Ribble Valley Borough Council
Housing & Development Control

Application no: **3/2021/1105**

Address: **Land at Morans Farm Pendleton Road Wiswell BB7 9BZ**

Proposal: **Discharge of conditions 4 (Construction Management Plan) 9 (Site Access) and 12 (Bat Roosting) of planning permission 3/2020/0981.**

**LOGISTICS PLAN**

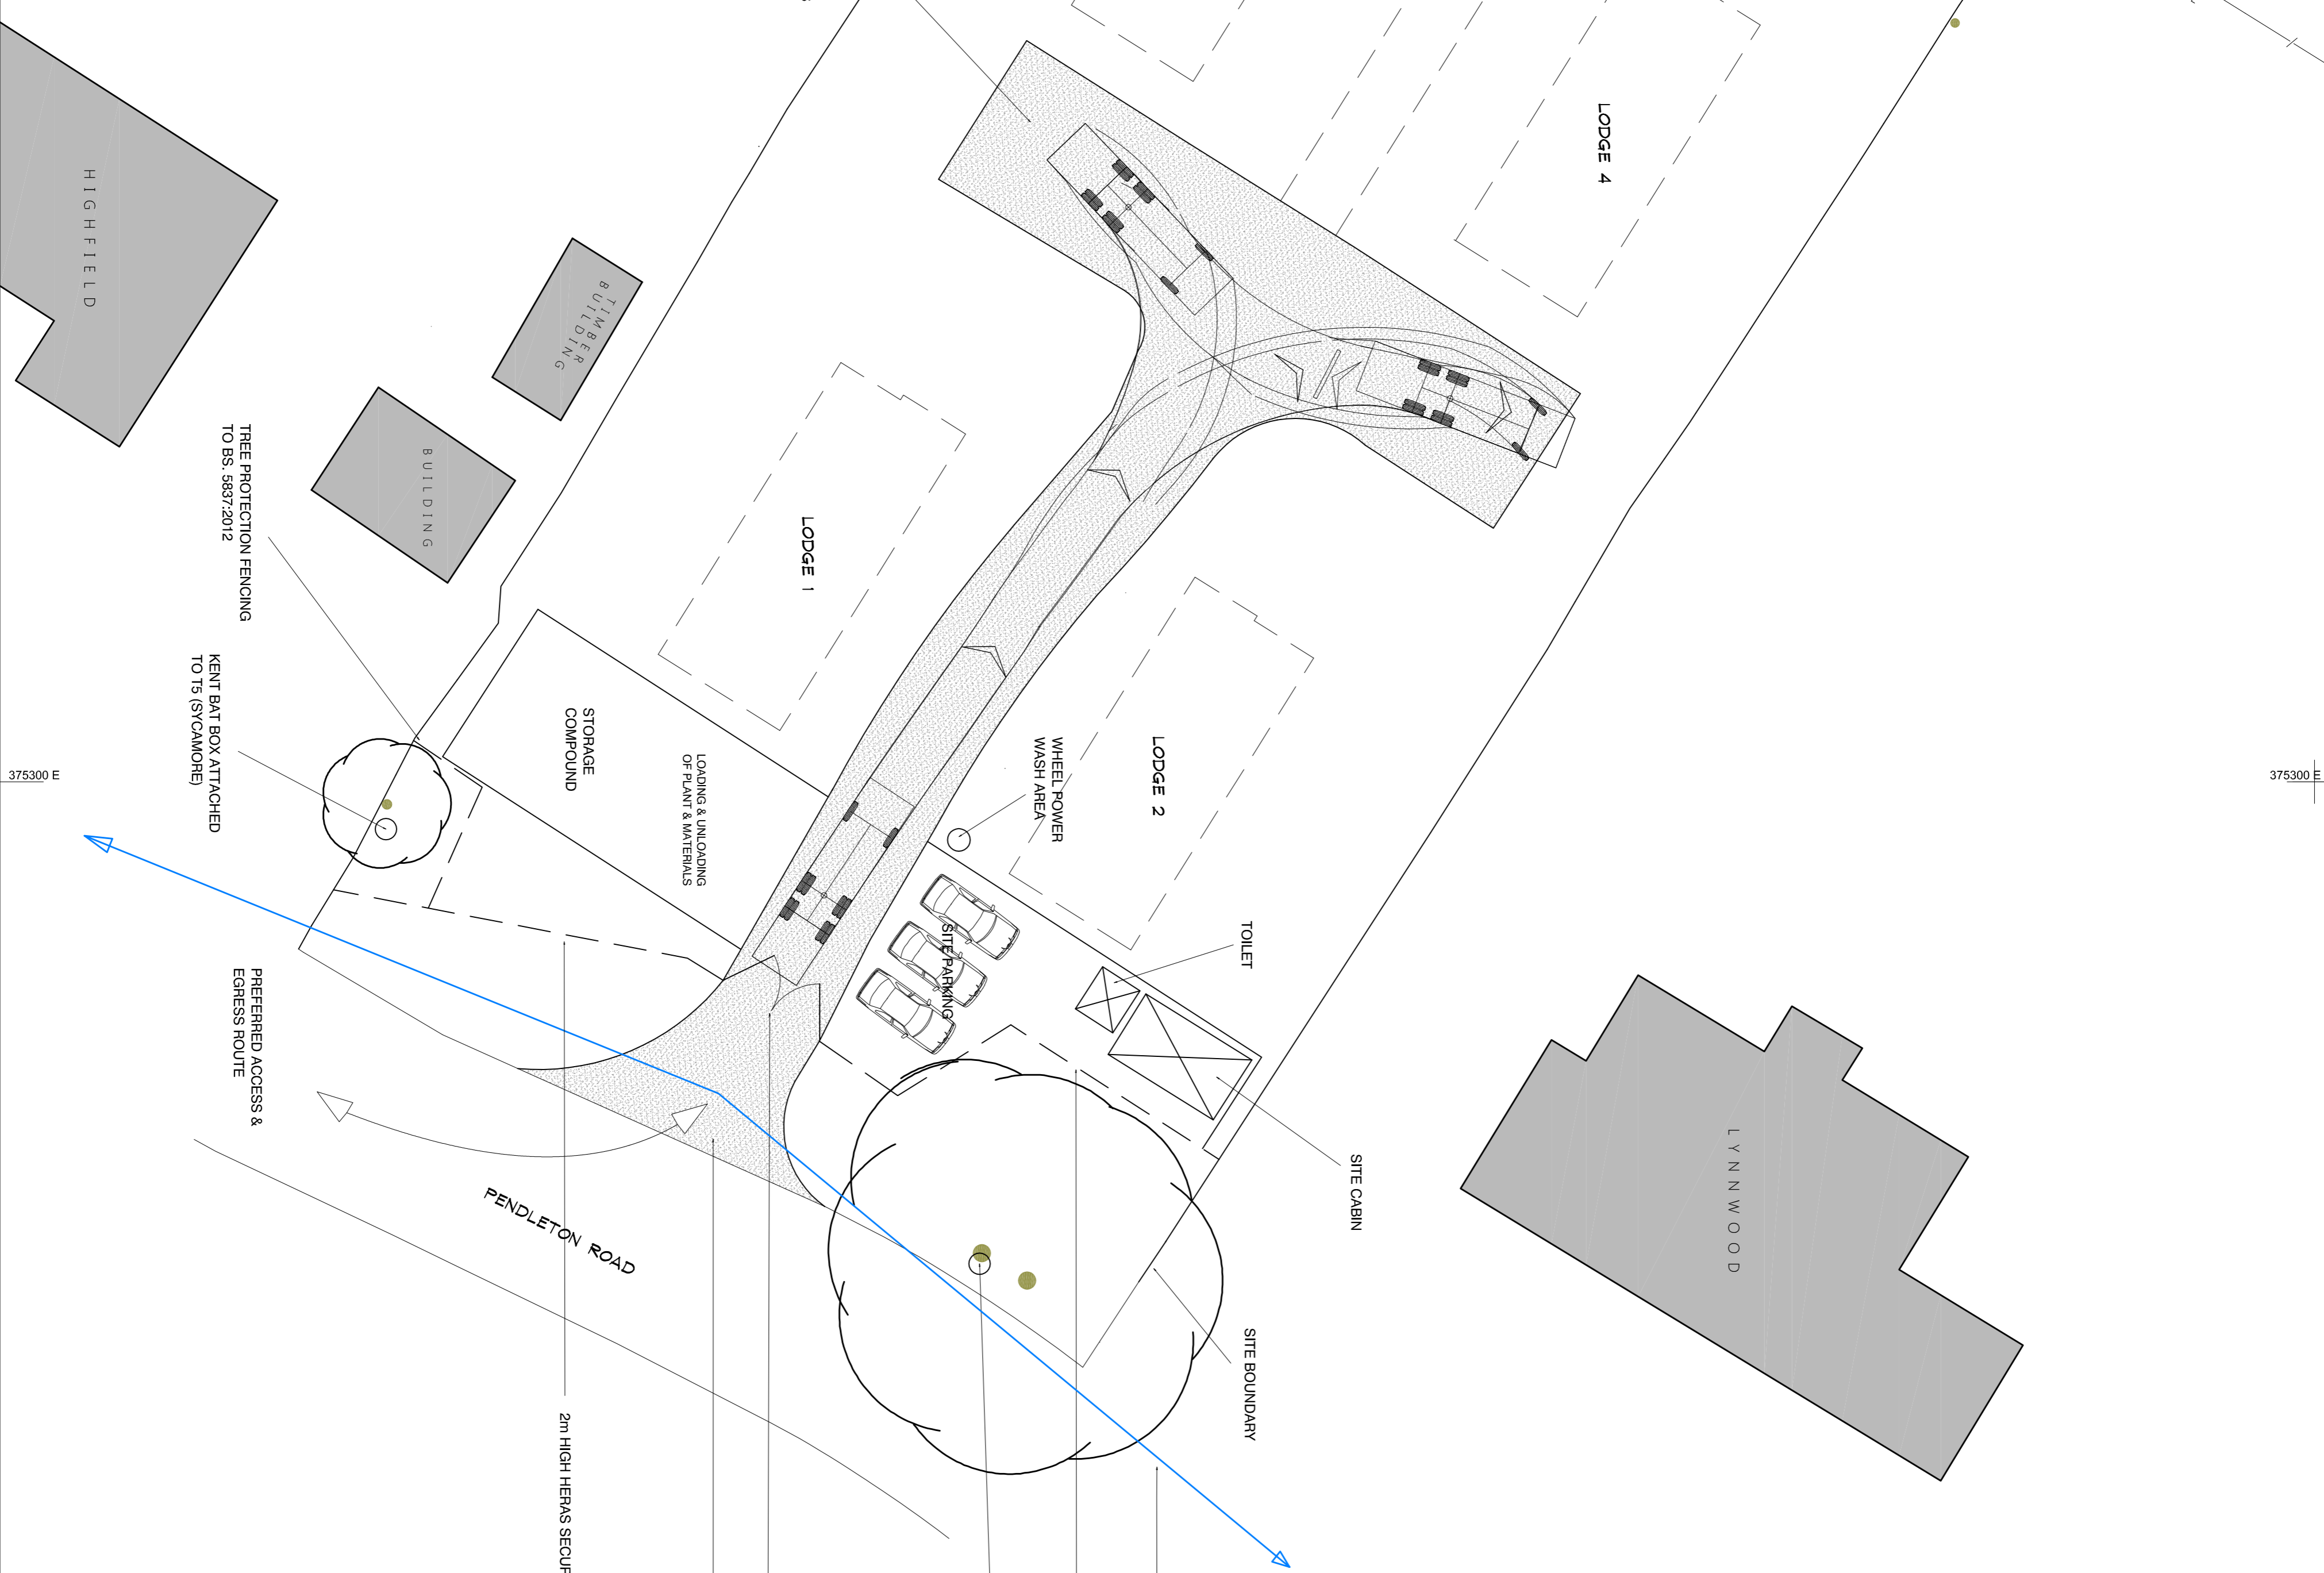
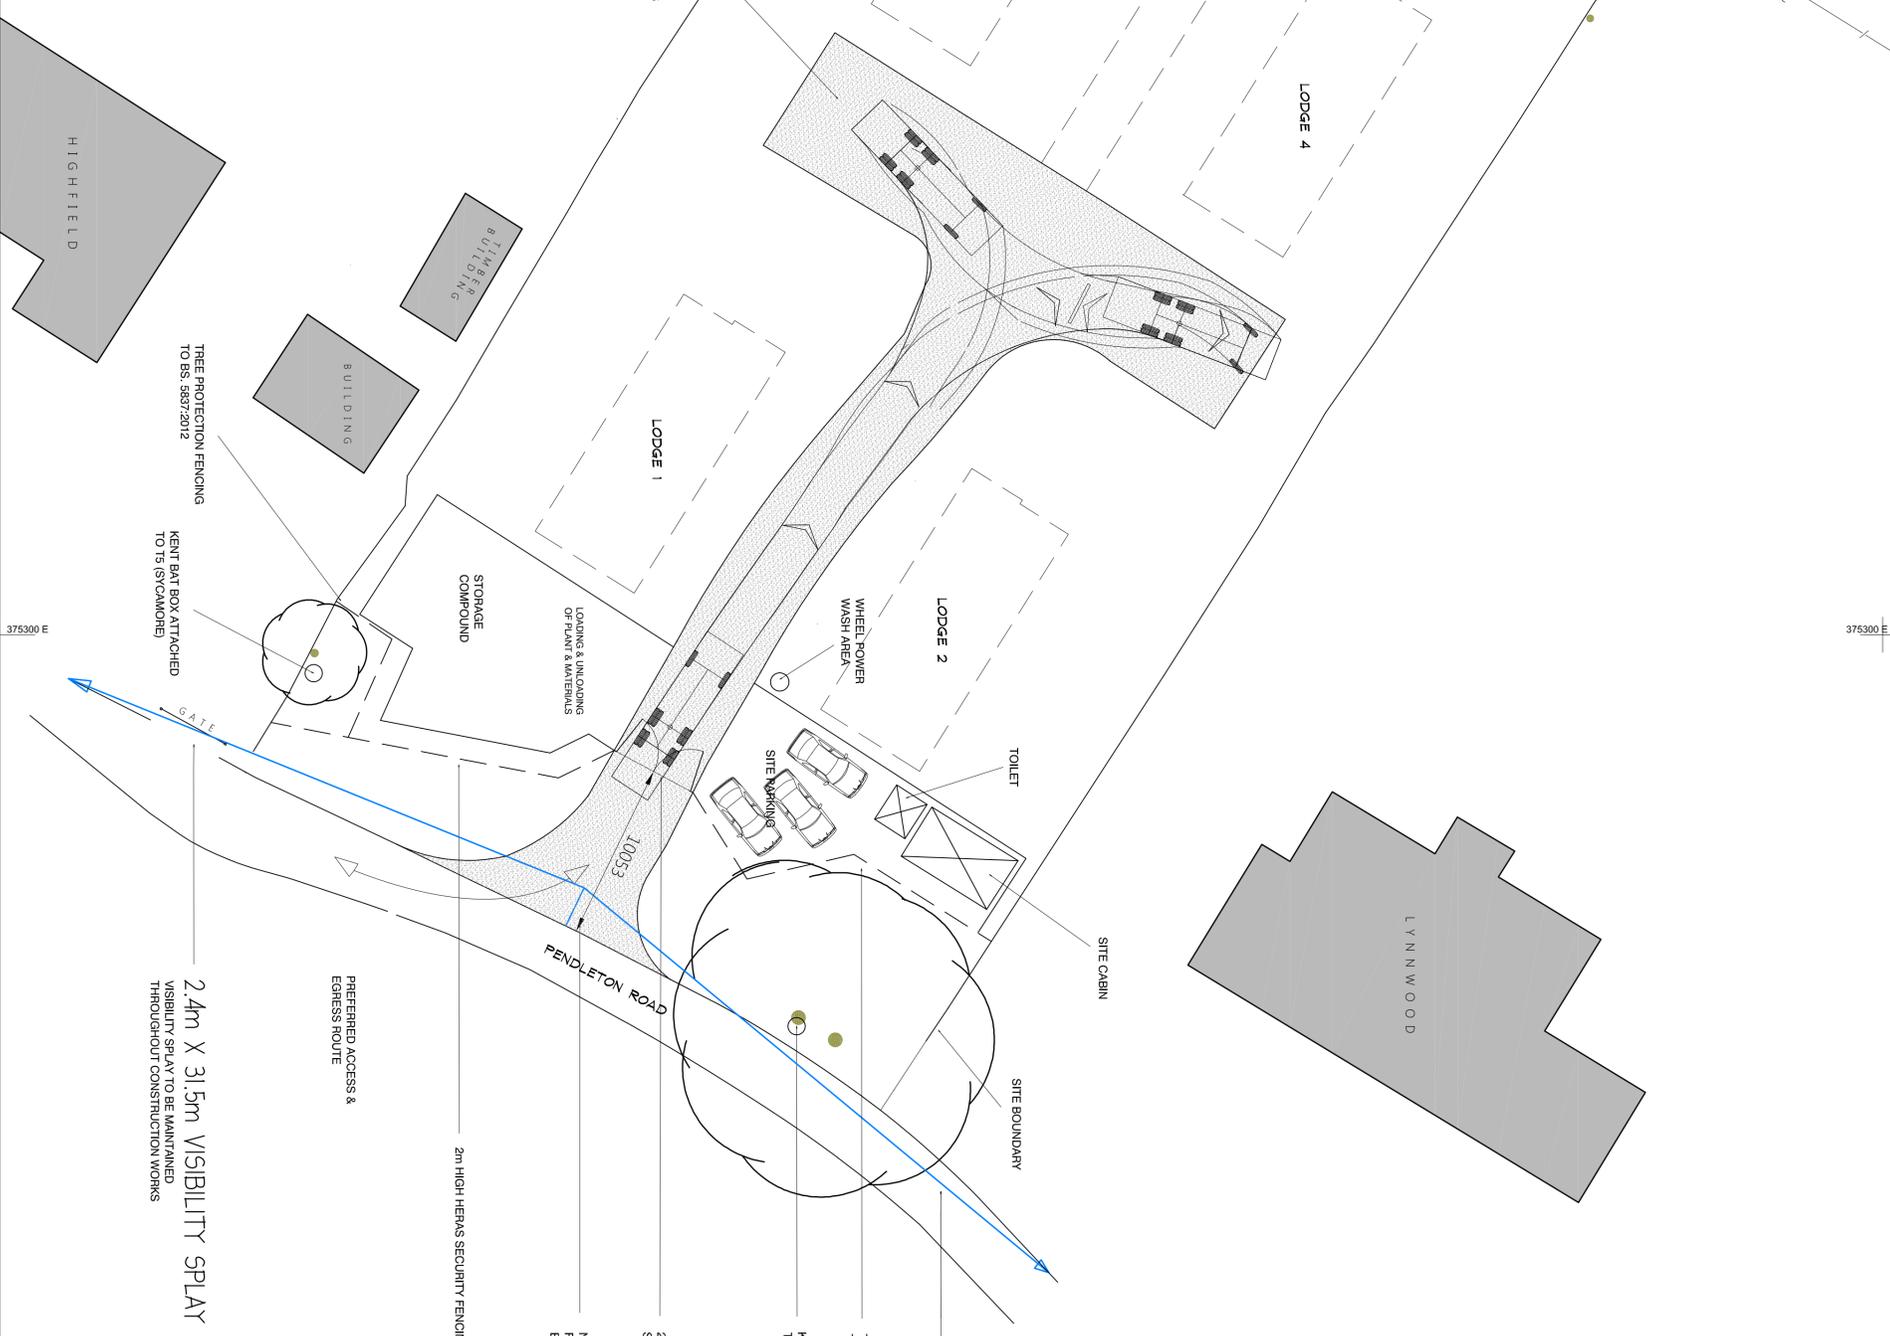
The LHA have reviewed ADM Design drawing number ADM/MORANS/LP titled "Logistics Plan" and are satisfied that the access width complies with the LHAs guidance. The LHA inform the Applicant that any works undertaken to the access should be subject to a S278 agreement.

The LHA are also aware that the access during the construction phase of the development will be gated. The LHA have reviewed the drawing and are aware that the gate is setback approximately 7.5m from Pendleton Road which is an unclassified road subject to a 60mph speed limit.

While the LHA would have no objection to the gate being setback this distance if it was just to serve the 4 holiday lodges and after the construction phase had ended, the LHA during the construction phase require the gate to be setback a minimum distance of 10m from the public highway. This is because the swept path analysis, which is shown on the drawing, shows that the largest vehicle will be approximately 9.9m in length. Therefore, should the gate be setback 7.5m, as identified on the drawing, the delivery vehicle will have to wait on the public highway to operate the gate. This could be to the detriment of highway safety, especially when Pendleton Road is subject to a 60mph speed limit.

Therefore, the LHA require the gate to be setback a minimum distance of 10m during the construction phase of the proposal and then a minimum distance of 5m when the access is serving the proposed 4 holiday lodges.

The LHA also request that the visibility splays which were agreed under application reference 3/2020/0981, are provided on the revised access drawing. The LHA accepted visibility splays of 2.4m x 31.5m to the right and 2.4m x 34.15m to the left of the access, following a speed survey undertaken by a Transport Consultant.

Once a revised drawing shows the gate is setback the required distance and the visibility splays are shown on the drawing, the LHA will have no objection to discharge the condition.
